Submissions in response to SSD-10421 WEIGALL SPORTS COMPLEX, SYDNEY GRAMMAR SCHOOL

NAME – [REDACTED]
ADDRESS – [REDACTED] Darlinghurst, 2010
DATE – December 2020

These submissions respond in both general and specific terms to the above SSDA comprising the construction of a sports complex and car park (**Development**) on what is currently green space in Neild Avenue, Paddington.

Drawing Title BUILDING 01 SPORTS FACILITIES BUILDING ELEVATIONS NORTH AND SOUTH Sheet Status NOT FOR CONSTRUCTION

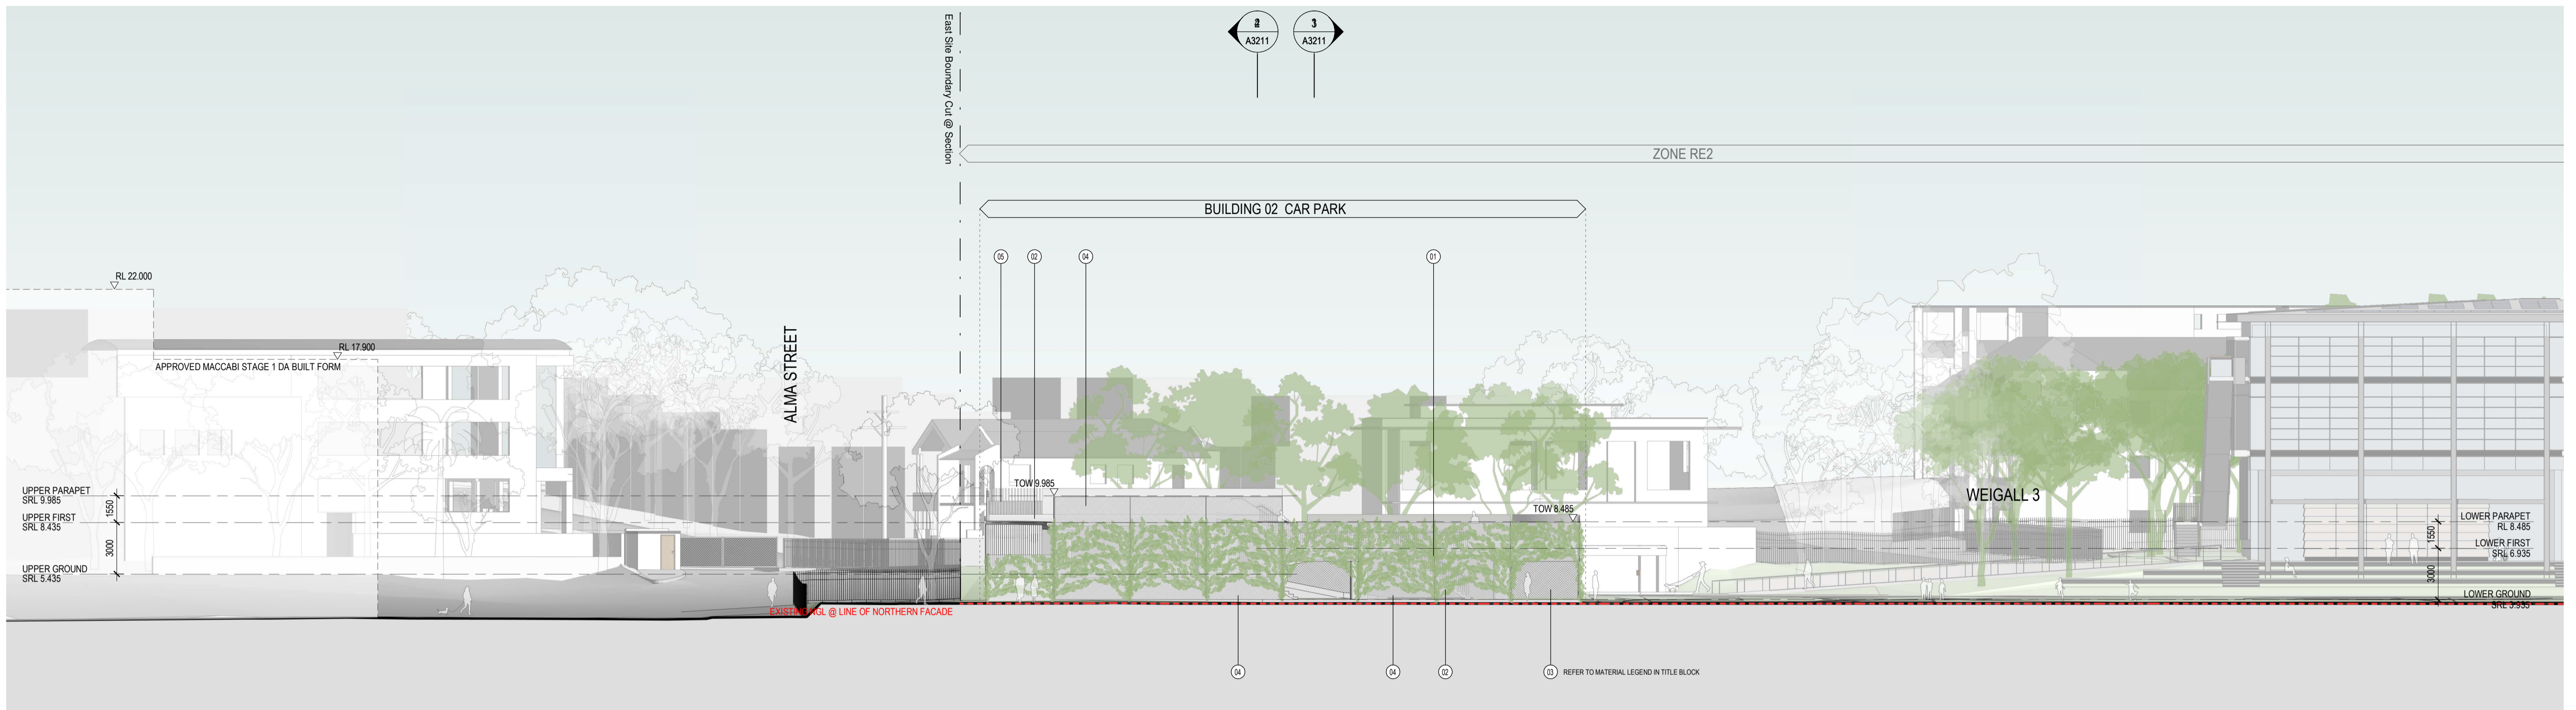
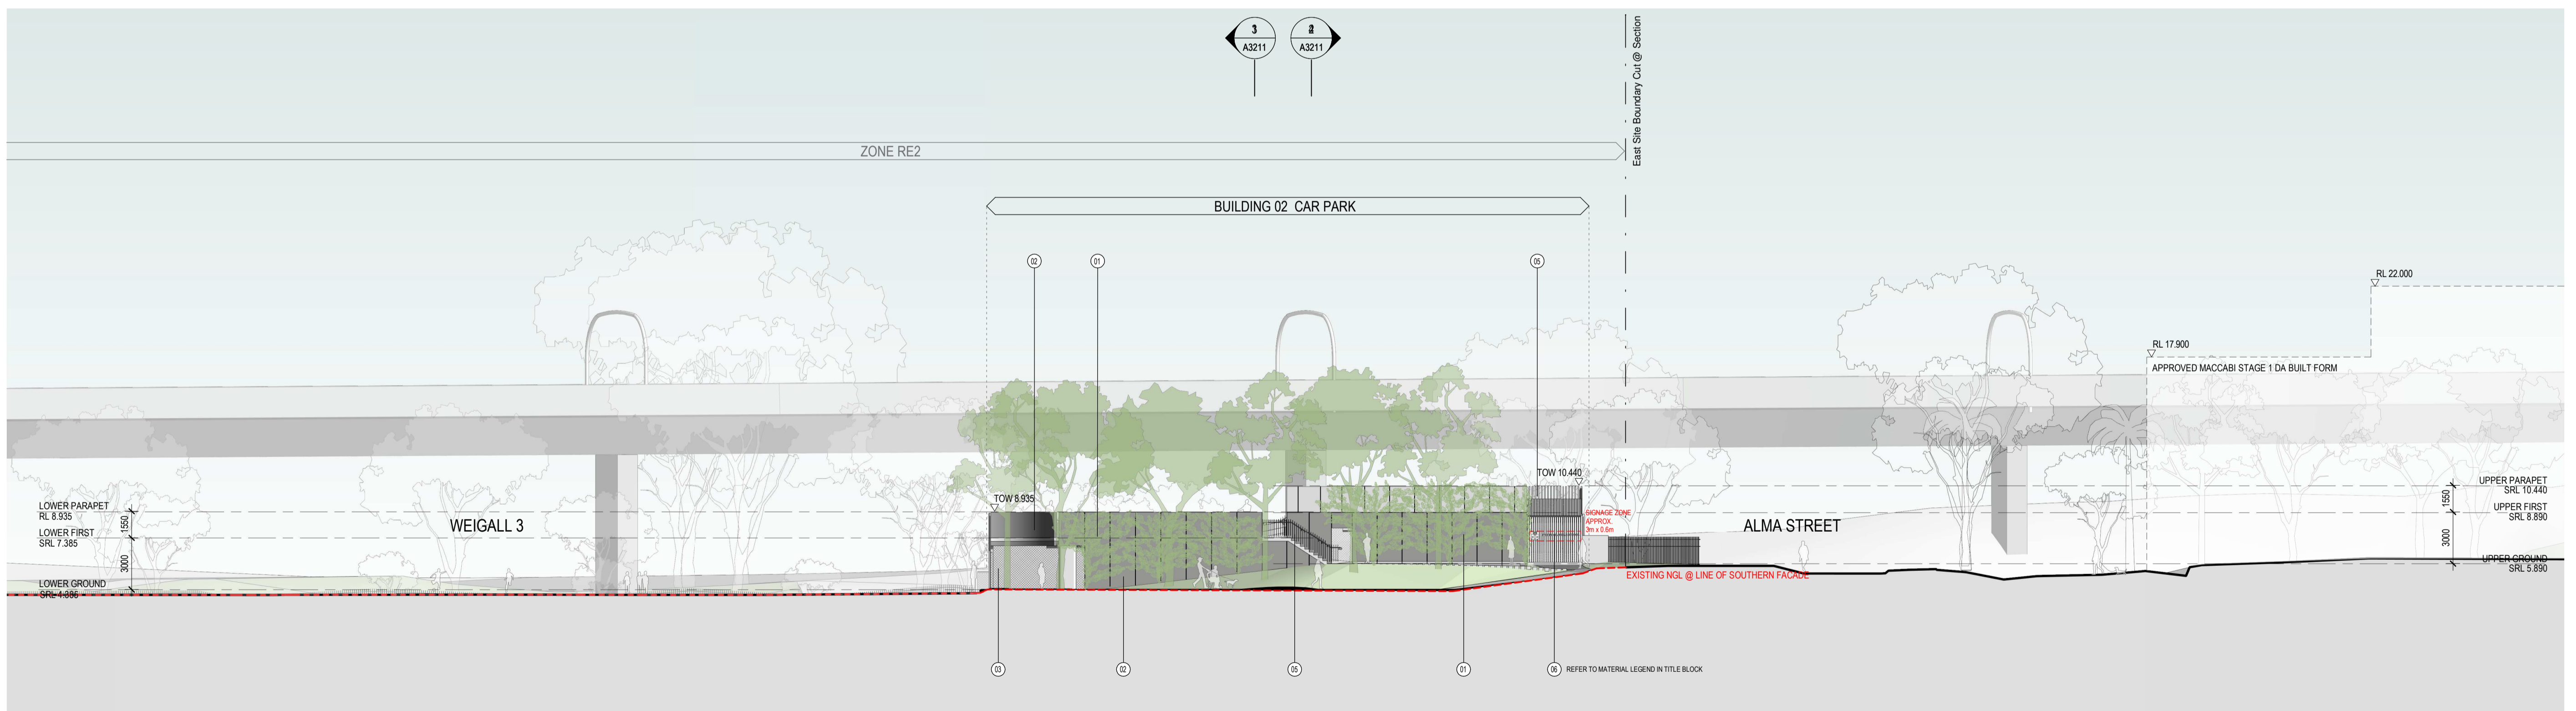
The finished Main Building will be approximately 17 metres tall and have a western face of over 55 metres and a northern face of over 60 metres. Despite some variations to the northern face, the building is a vast rectangular bulk when looked at from much of Neild Ave (at the western and north western side of the Development).

Affected Neild Ave Properties anywhere to the north of the Main Building will not only face the bulk of the western wall of the Main Building, but also the northern face of the Main Building (to a greater or lesser degree depending on angulation). At present, these properties' view of what will be the northern face of the Main Building comprises green space, a small, old-fashioned style, pavilion in muted colours and several mature pepper trees (all slated for removal). As there is currently no planting or landscaping for the north face of the Main Building these Affected Neild Ave Properties will doubly visually affected (as well as in other ways) as they will be exposed to the both the northern side and western side of the Main Building.

1 EAST ELEVATION

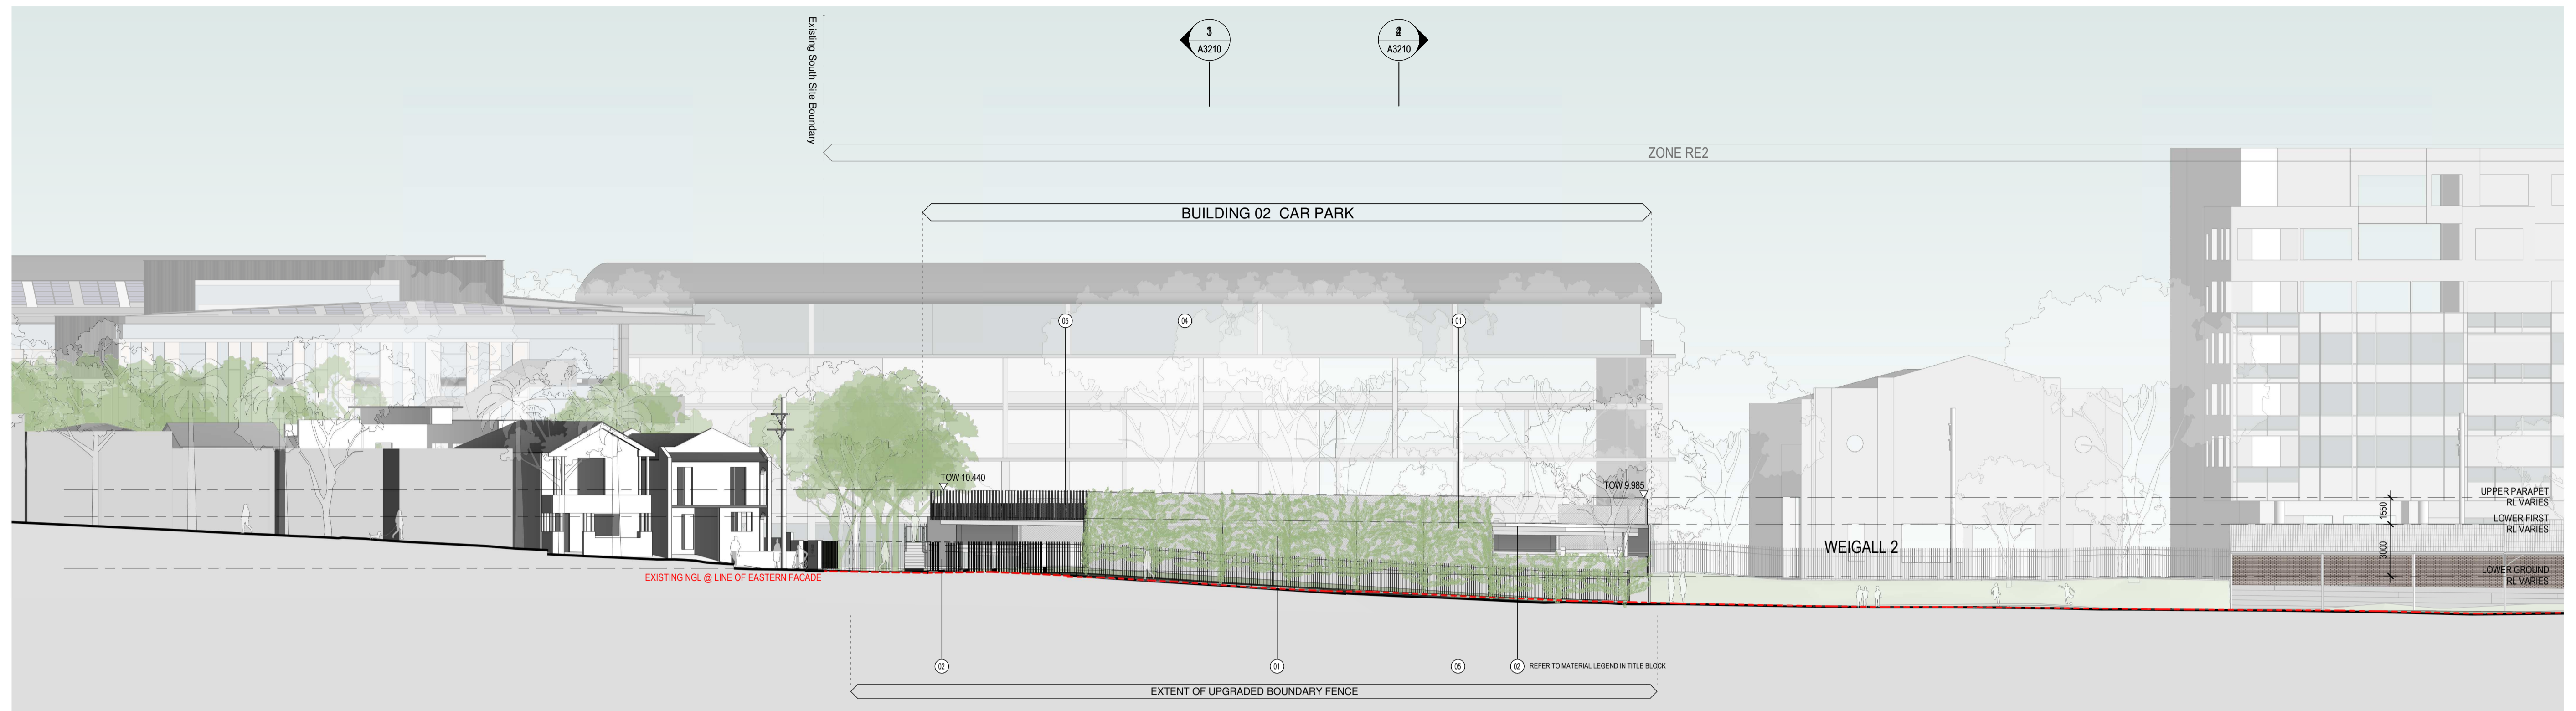
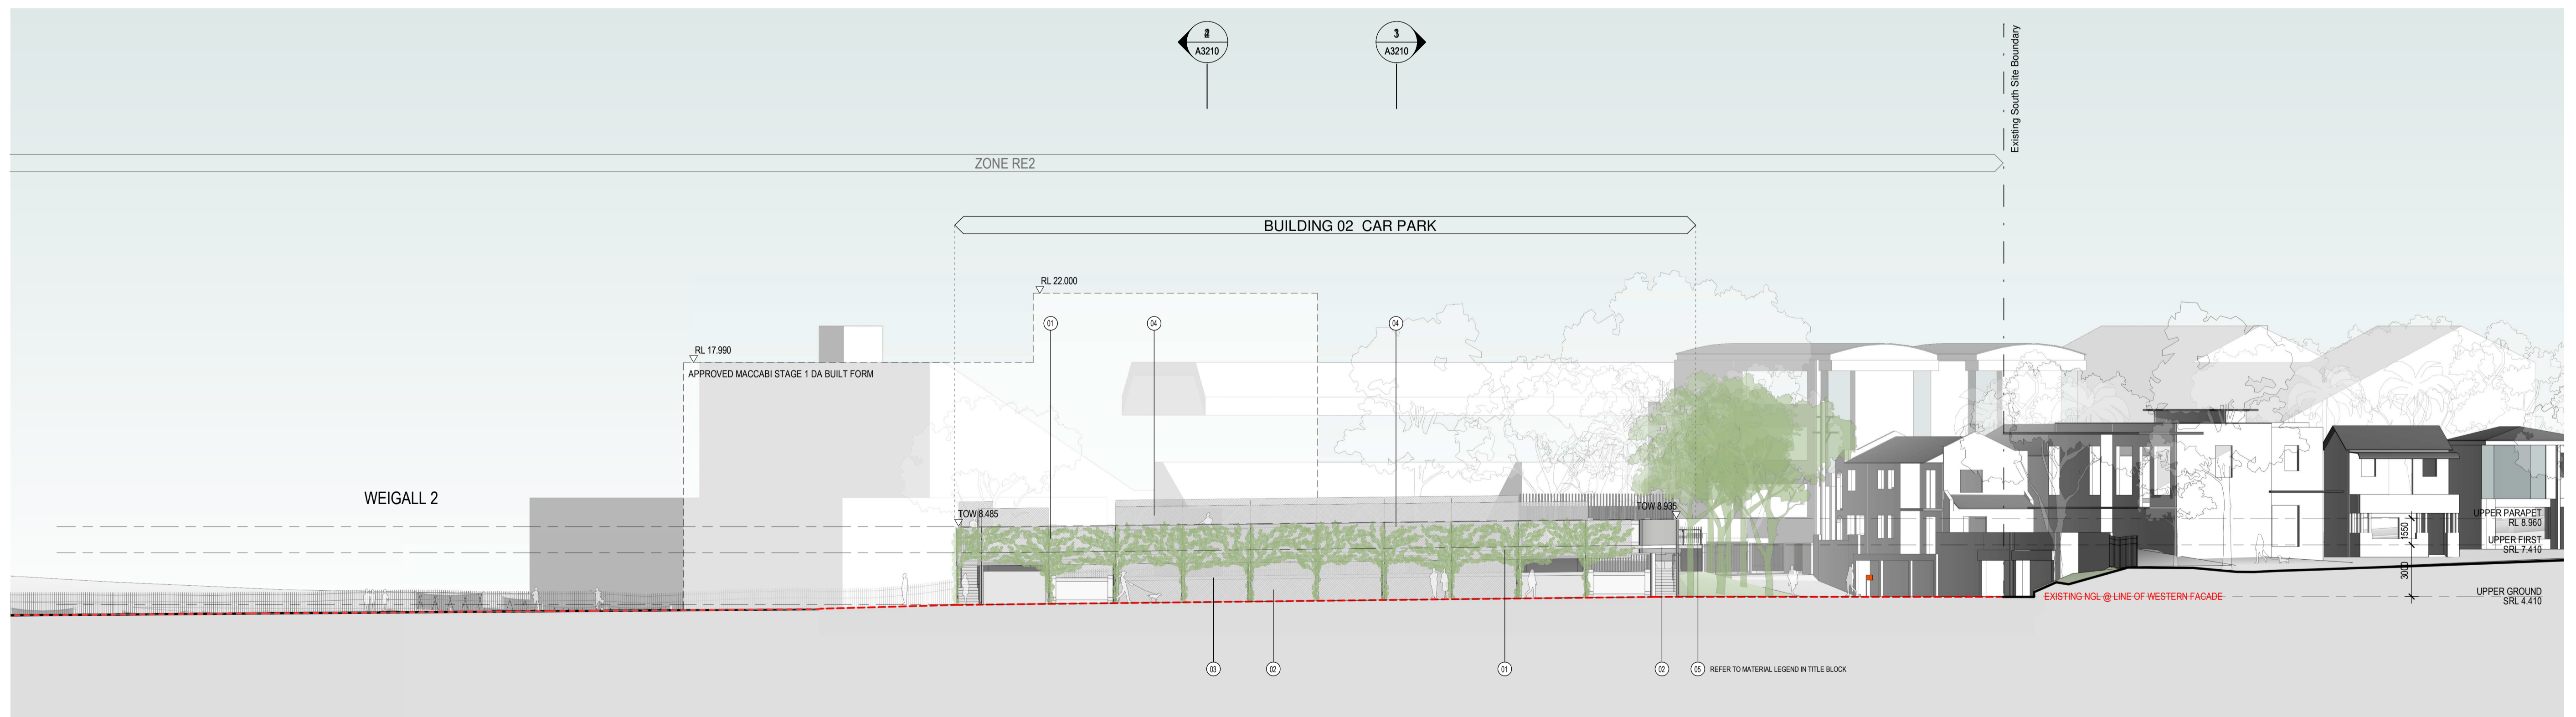
Exacerbating this impact is the fact that along Neild Ave, the western facing building form façade is a solid wall mass and there is insufficient specification for the planting of trees to replace the significant tree loss. In fact, unlike residents to the south and east of the Development, the Affected Neild Ave Properties who were omitted from the assessment, are, under the Development as proposed, left facing the full bulk and height of the Development, which will have a high impact and little to “mitigate the effects of the bulk and scale of the proposed development” – (Visual Impact Assessment Report, Photo Montage pp21 and 23)

- **that any approval of a Weigall Development specify landscaping measures that include planting a mixture of mature, tall (>3metre) trees in order to mitigate the visual impact including:**

- **on the western side of the Main Building;**
 - **further north and south inside the Neild Ave boundary of the Weigall Playing Fields; and**
 - **on the north side of the Main Building, particularly the northern side of the Western Building.**
